Recommendation Report for Planning Permission for Works or Extension to a Dwelling

REF NO: R/85/21/HH

LOCATION: 9 Cove Road
Rustington
BN16 2QW

PROPOSAL: Erection of part single and part two storey rear and side extension, garage conversion and alterations to fenestration/openings following the demolition of existing rear conservatory.

EXISTING AND PROPOSED GROUND FLOOR PLANS
PROJECT – INTERNAL ALTERATIONS AND EXTENSIONS

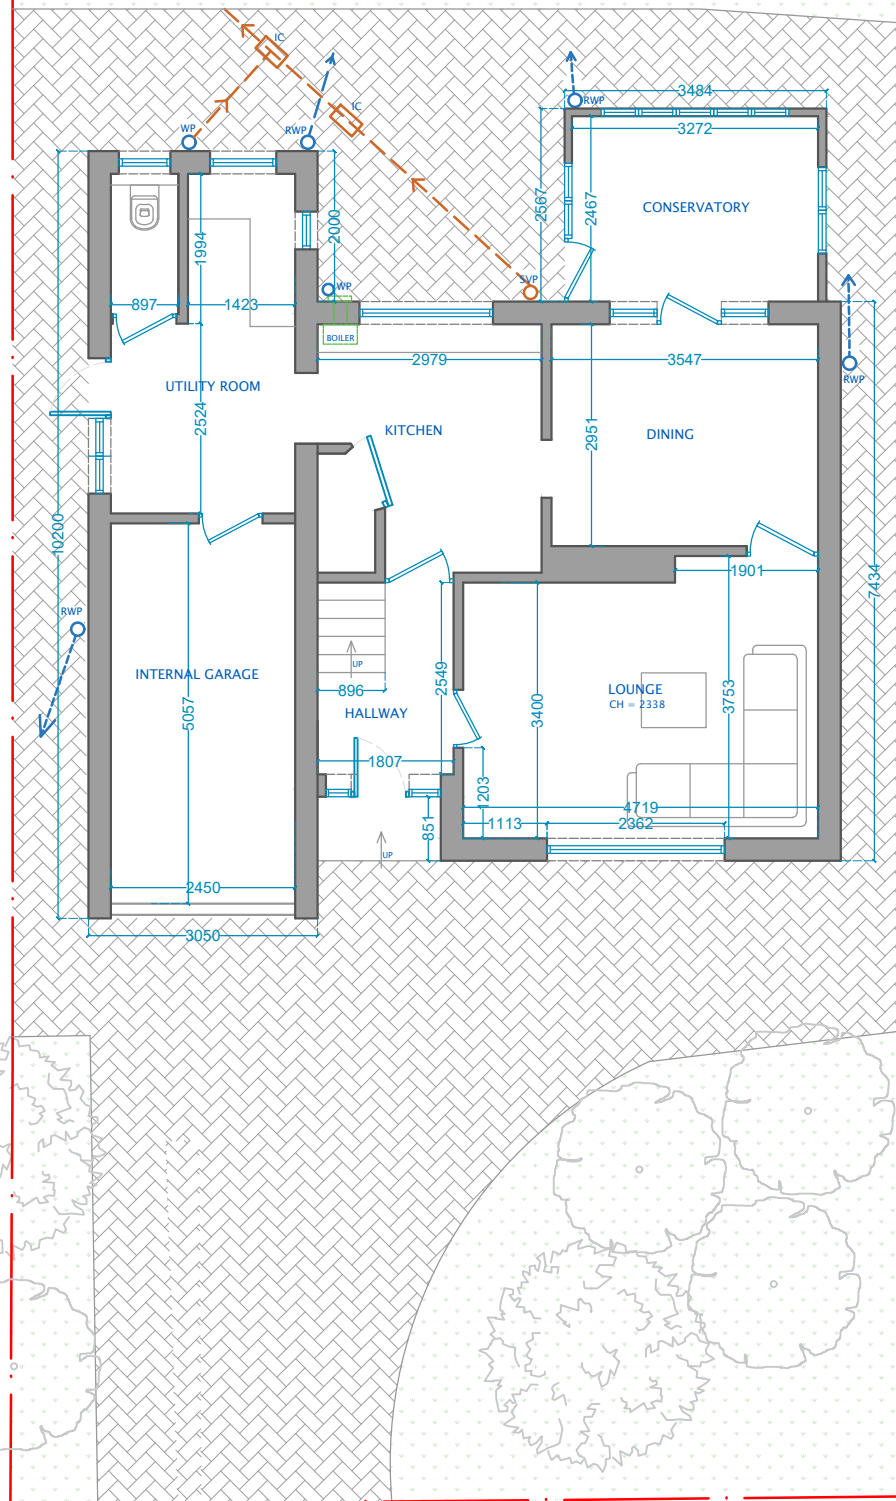
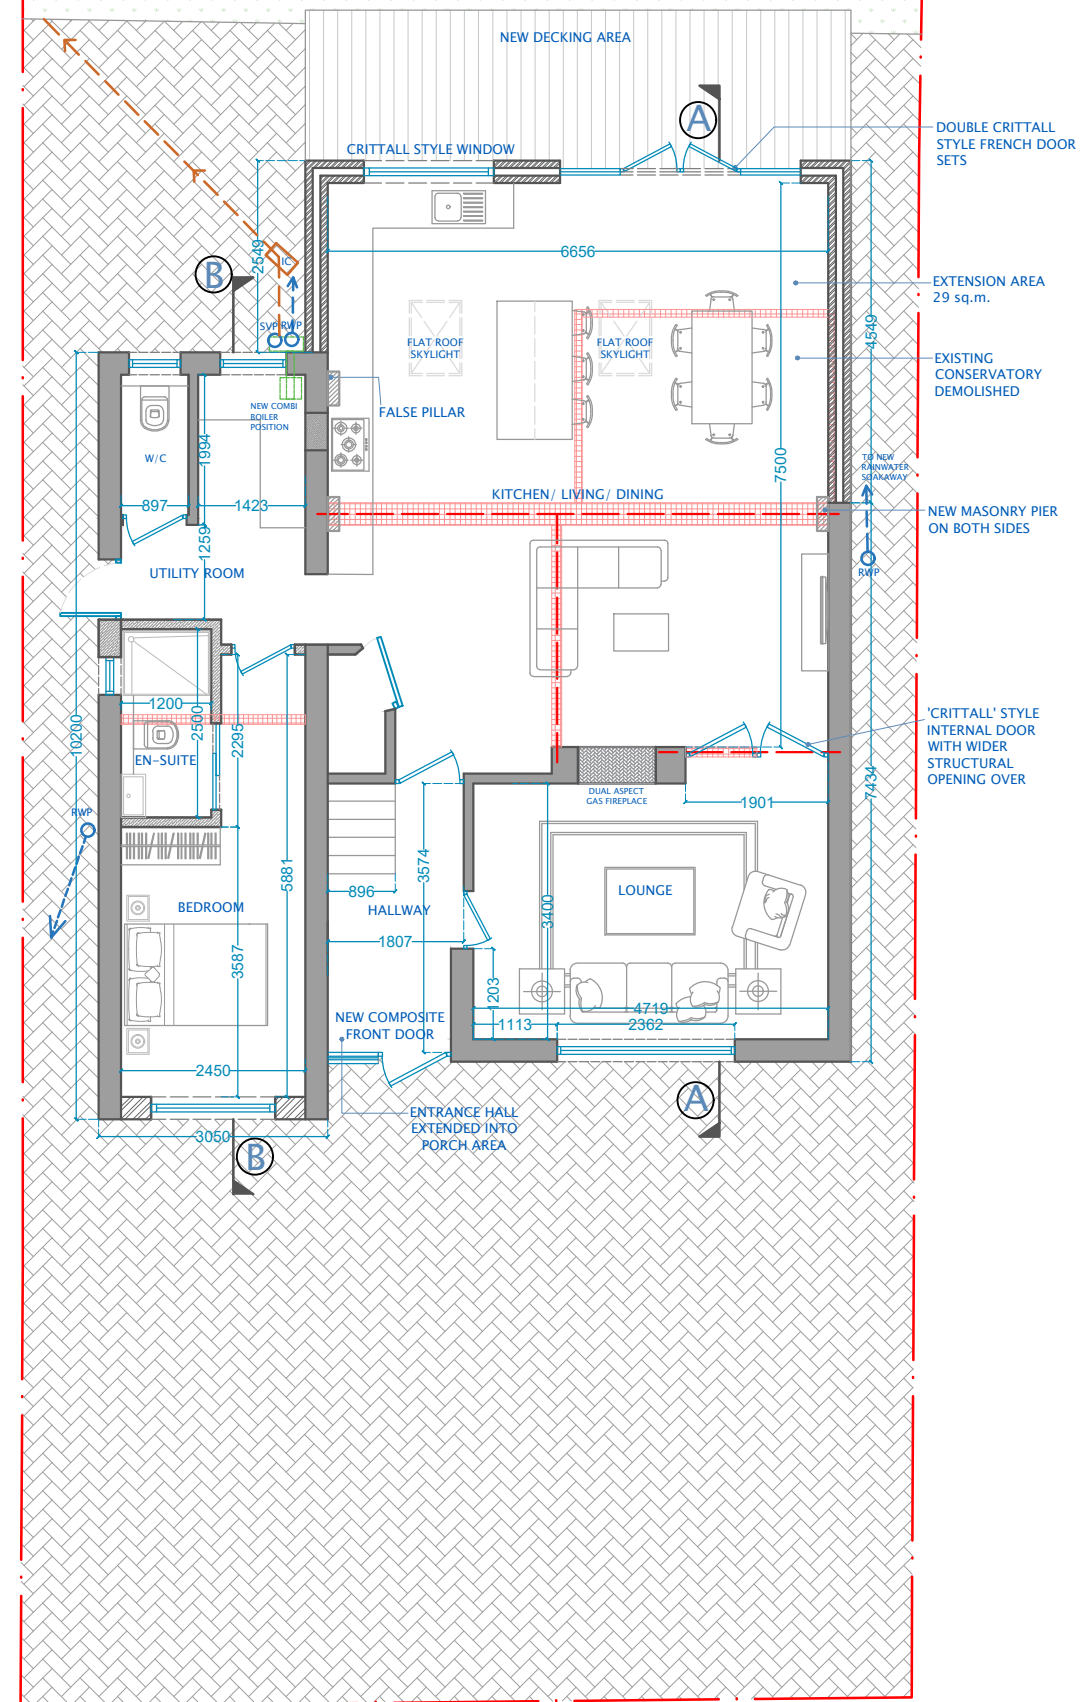
The side extension which would be built above the garage and the roof profile would be altered incorporate a hipped roof. The development, whilst large, blends in with the built form of the dwelling. The proposal involves alterations to the fenestration pattern and removal of the garage door and insertion of a window.

Garage conversion into habitable use would result in loss of f parking. The front driveway could facilitate additional parking space. Proposal complies with T SP1 of the Arun Local Plan.

FRONT ELEVATION - PROPOSED

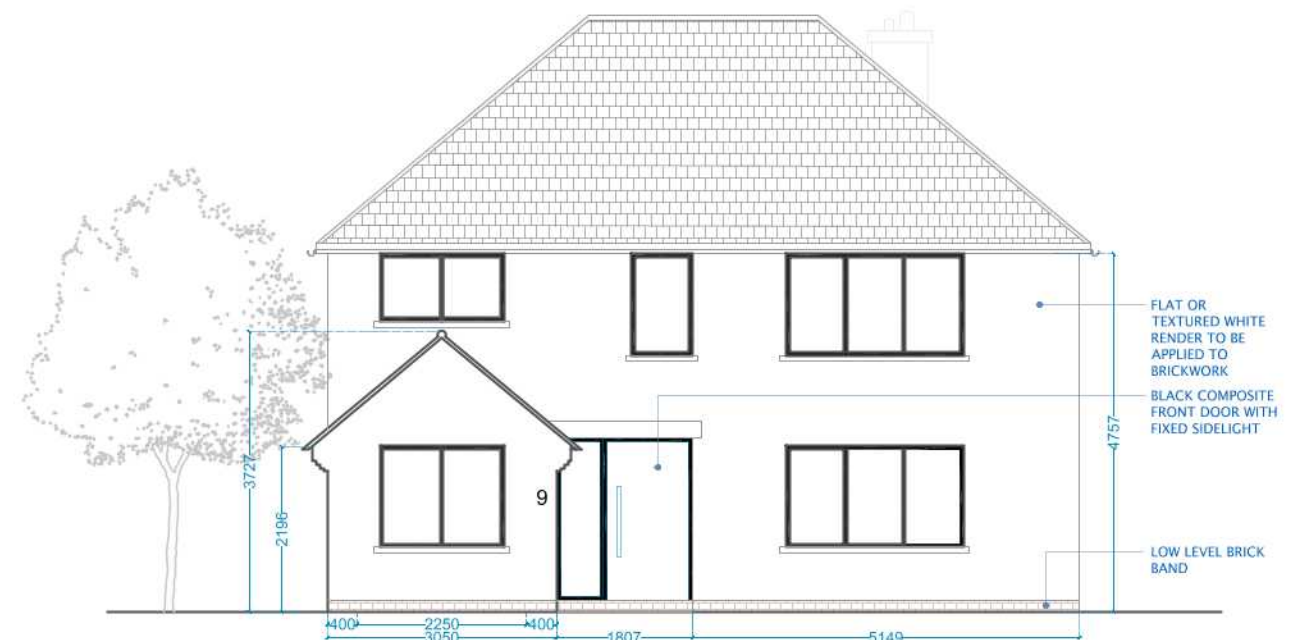
The proposal does conflict with advised contained in Class M of the Design Guide because the side extension is built flush with the host dwelling; however this does not significantly alter the appearance nor it creates an terracing effect. It is noticed that street scene is characterised by similar types of alterations and extensions, the proposed development is not considered to have significant harm on the visual amenity of the street scene. The side extension and alterations would uplift the dwelling to provide more contemporary appearance which is supported by class M of the design guidance and NPPF. The part rear single rear extension would not visible from the public domain and therefore development would have lesser impact on the street scene. The existing materials are standard brick finish and rendered white finish has been proposed. Brisk finish and rendered finish is quite prominent finish within the street and some properties contain both.

EXISTING AND PROPOSED FIRST FLOOR PLANS

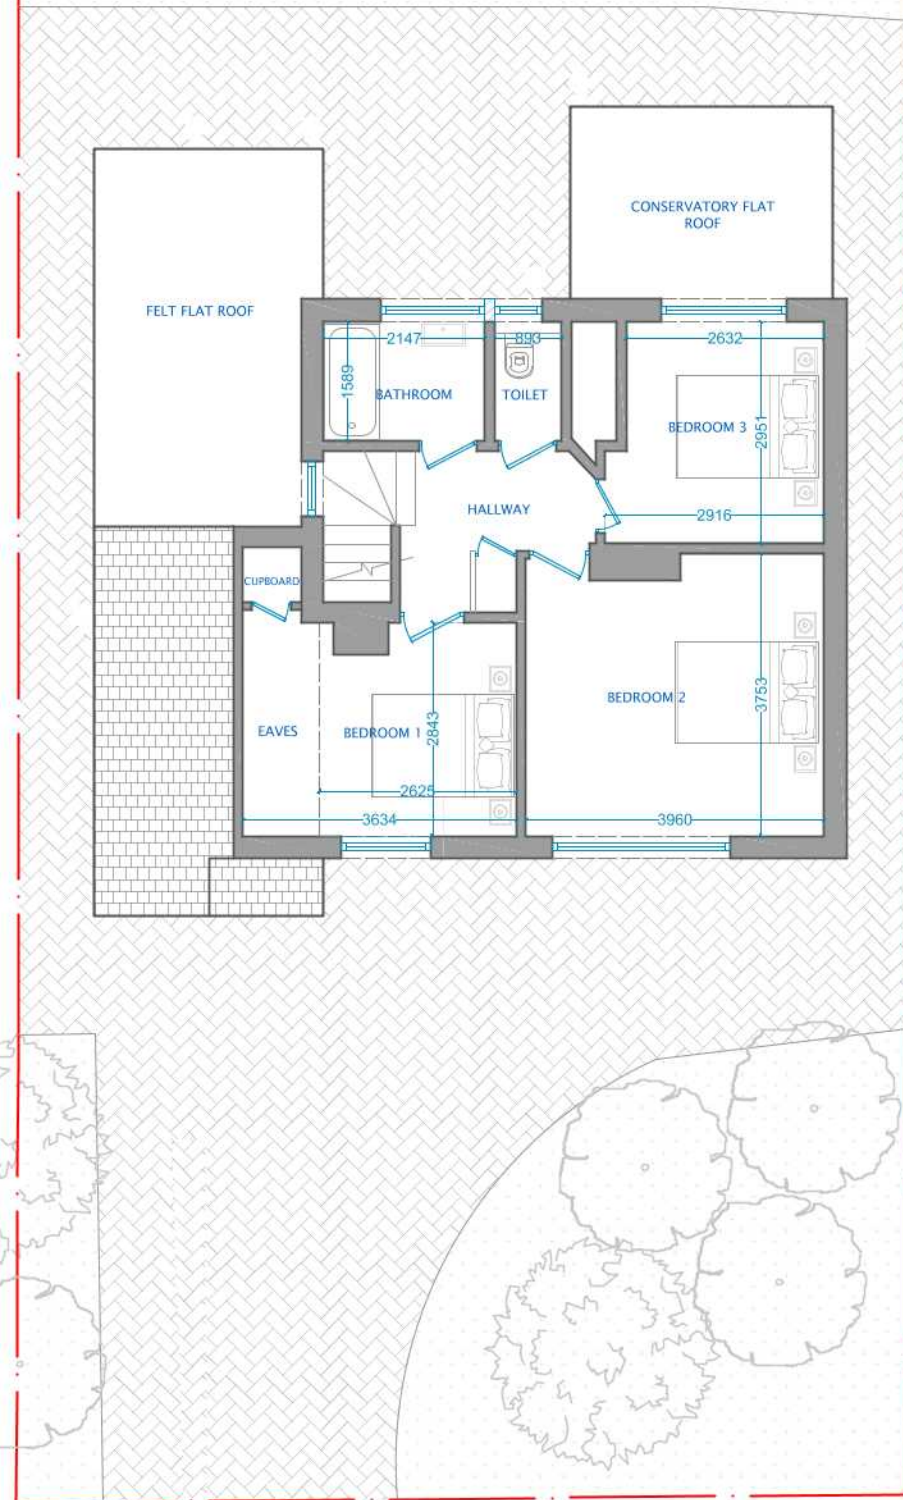
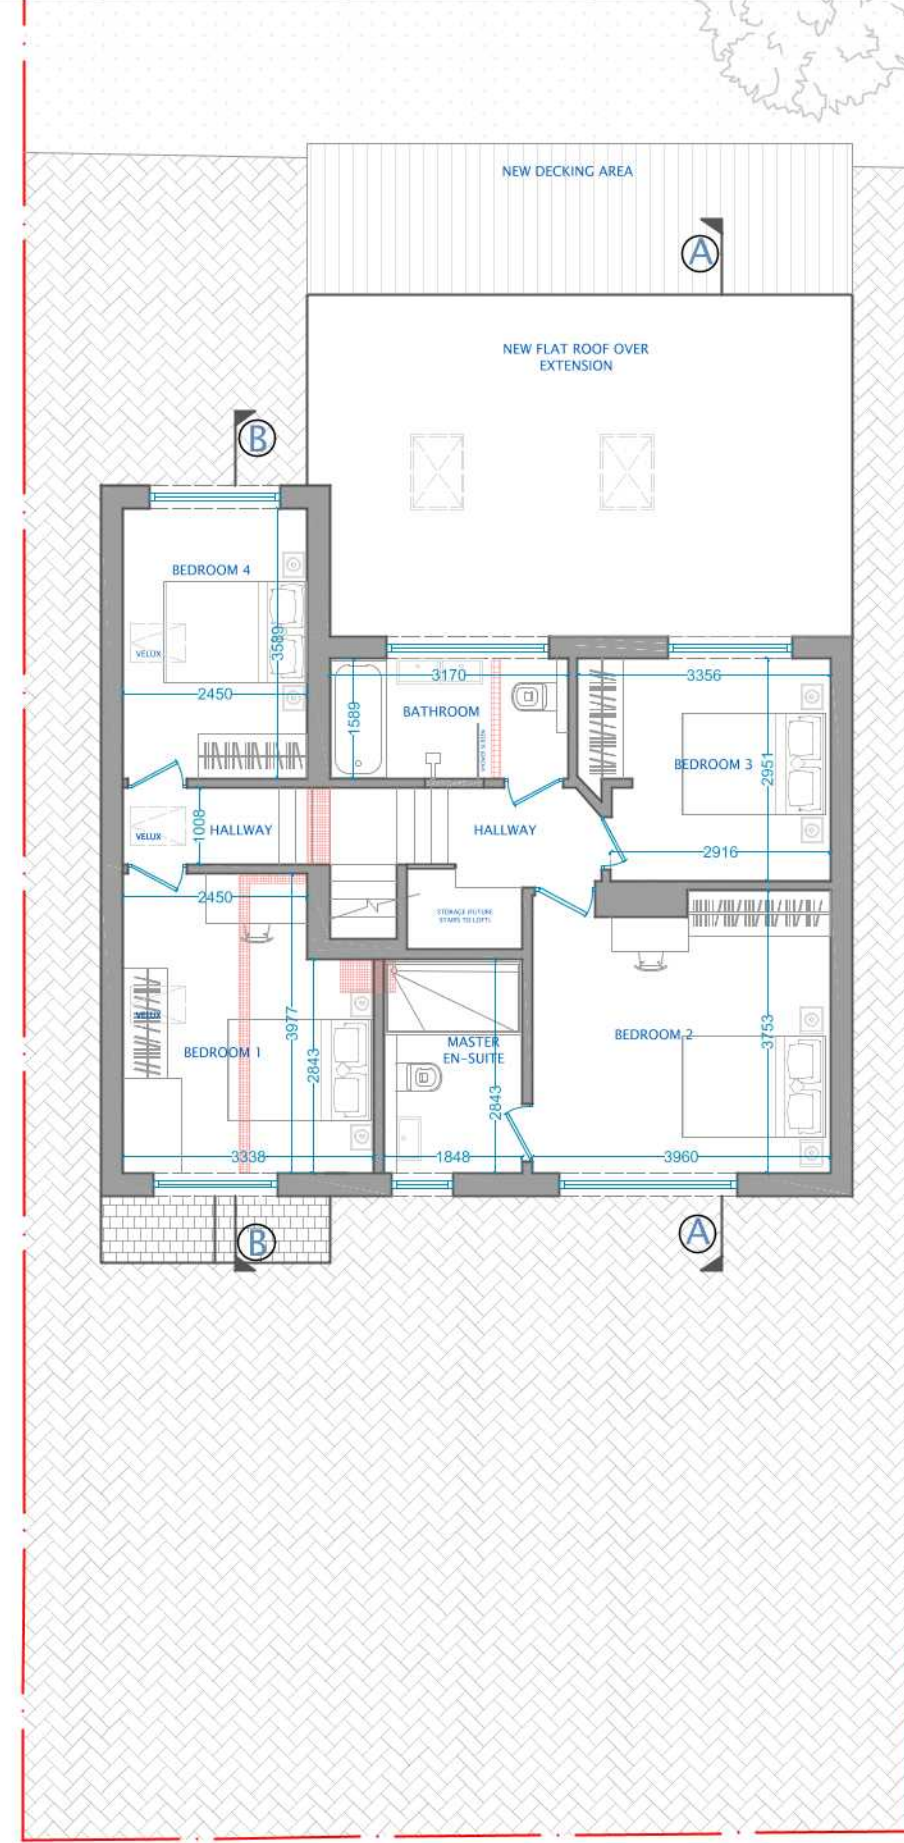
The part two storey rear extension is limited in scale and approximately measures (2.78m in depth). The existing single storey extension measures 2.36m in depth and overall depth of the extension would measure 4.26m and height is below 3m with flat roof. However, up to 4m could be built under provisions of the permitted development.

In this case development does conflict with the class M design guide; whilst the refusal cannot be justified. The 45-degree line has been shown on the plans which does not indicate any loss of light or overbearing impact on the adjoining dwelling. The detached nature of the plots and distance from the boundary helps mitigate impact of the development. Therefore, no demonstrable harm is demonstrated to residential amenity. The development is not considered to harm neighbouring amenity by way of overbearing, overshadowing or overlooking and accord with D DM1 and D DM4 of the Arun Local Plan.
